THE RESERVE AT CORRAL BLUFFS SUBDIVISION

Construction Drawings

El Paso County, Colorado

**C1**

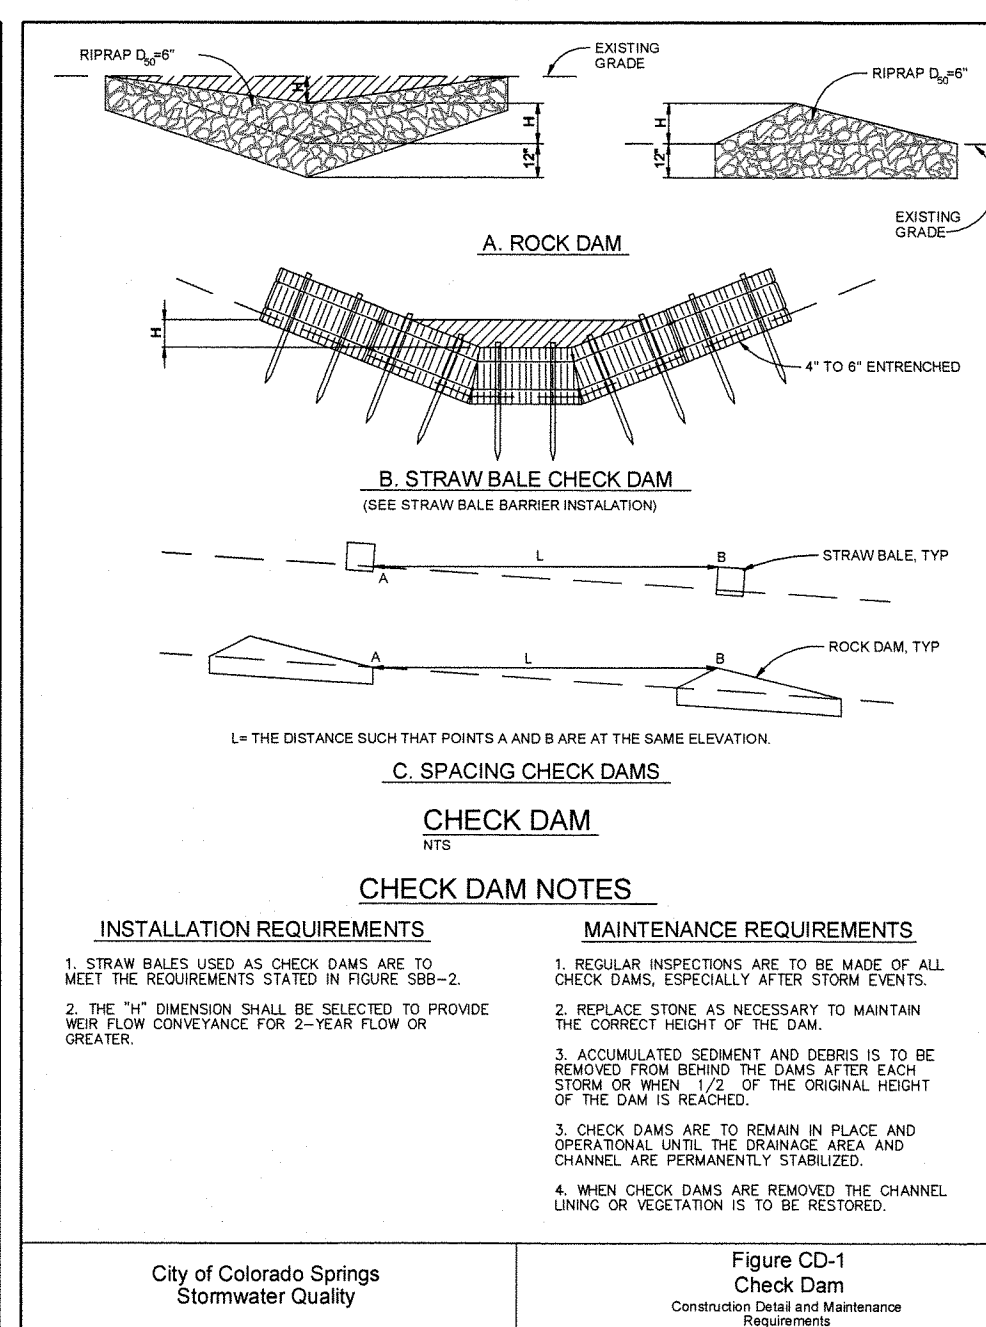
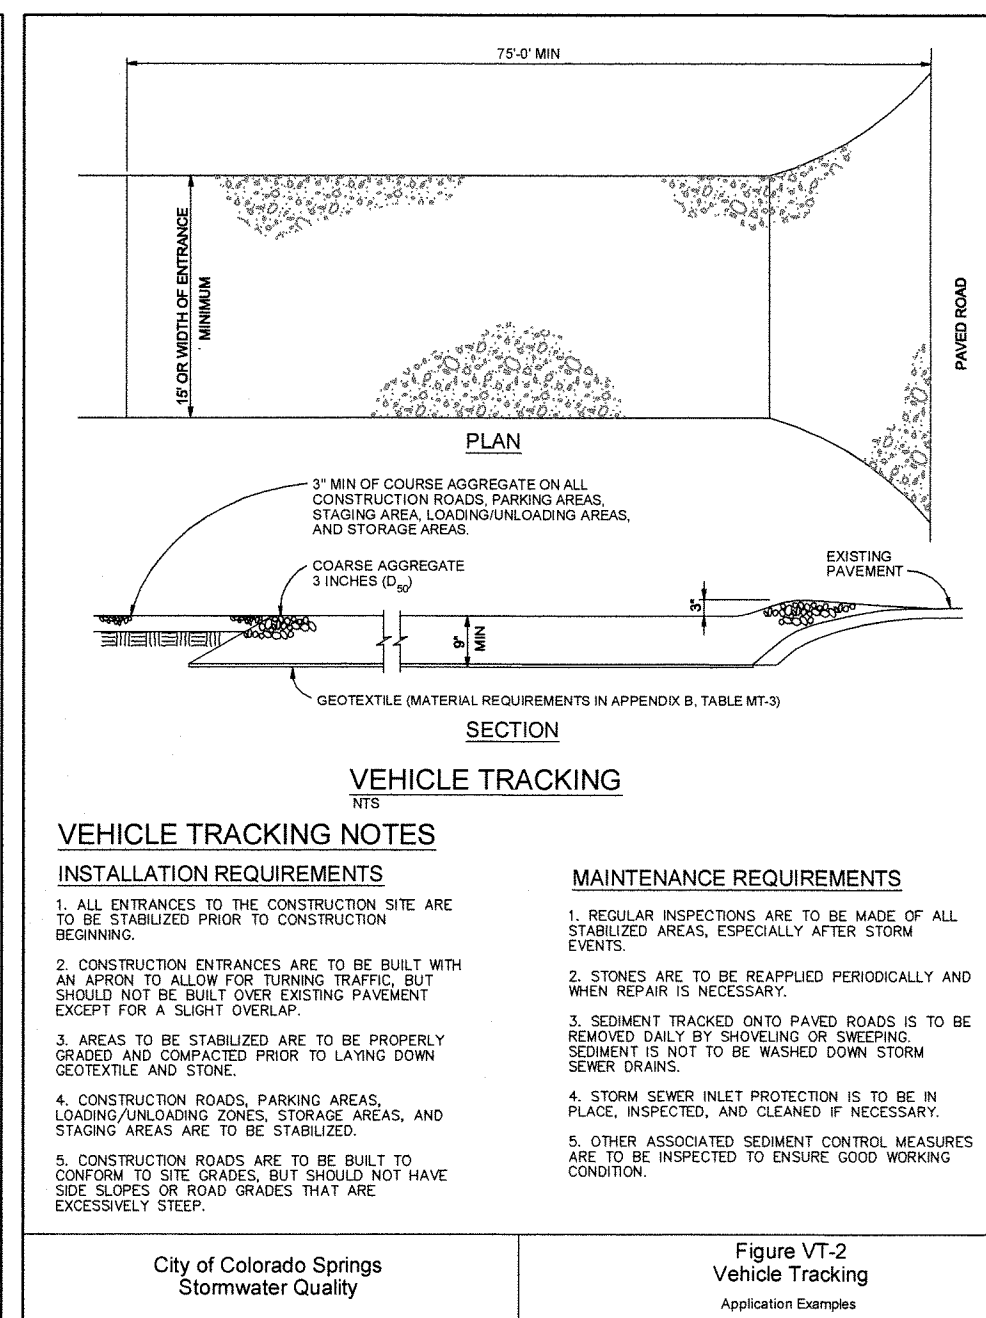
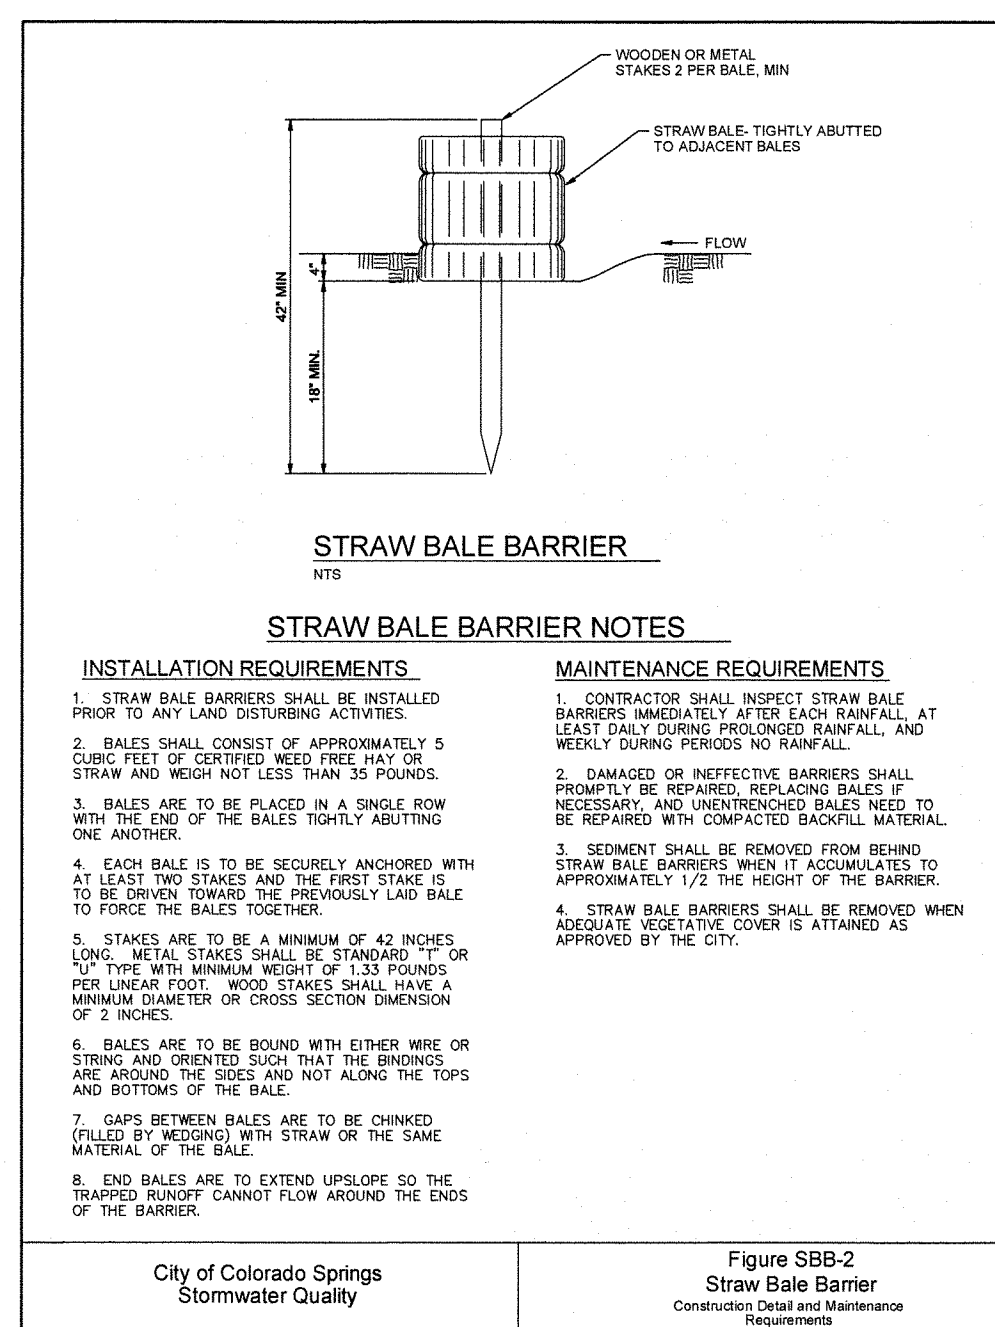
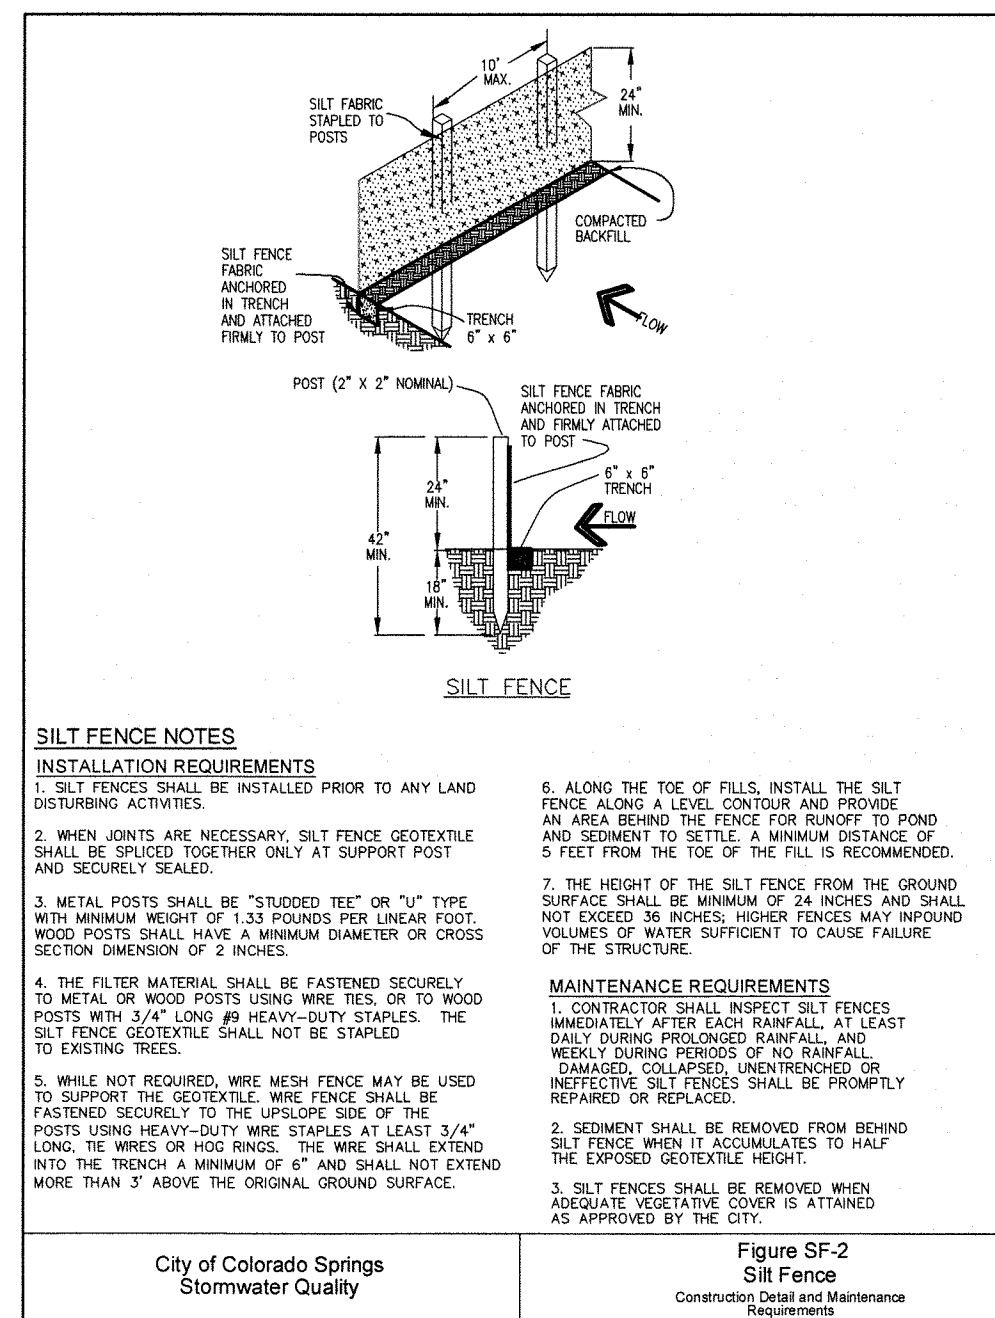
Identify Filing 2. FAE should match.

Update for Filing 2

Update the GEC to show VTC at the entrance to Filing 2 and the removal of the temp cul-de-sac.

Identify the inlet protection
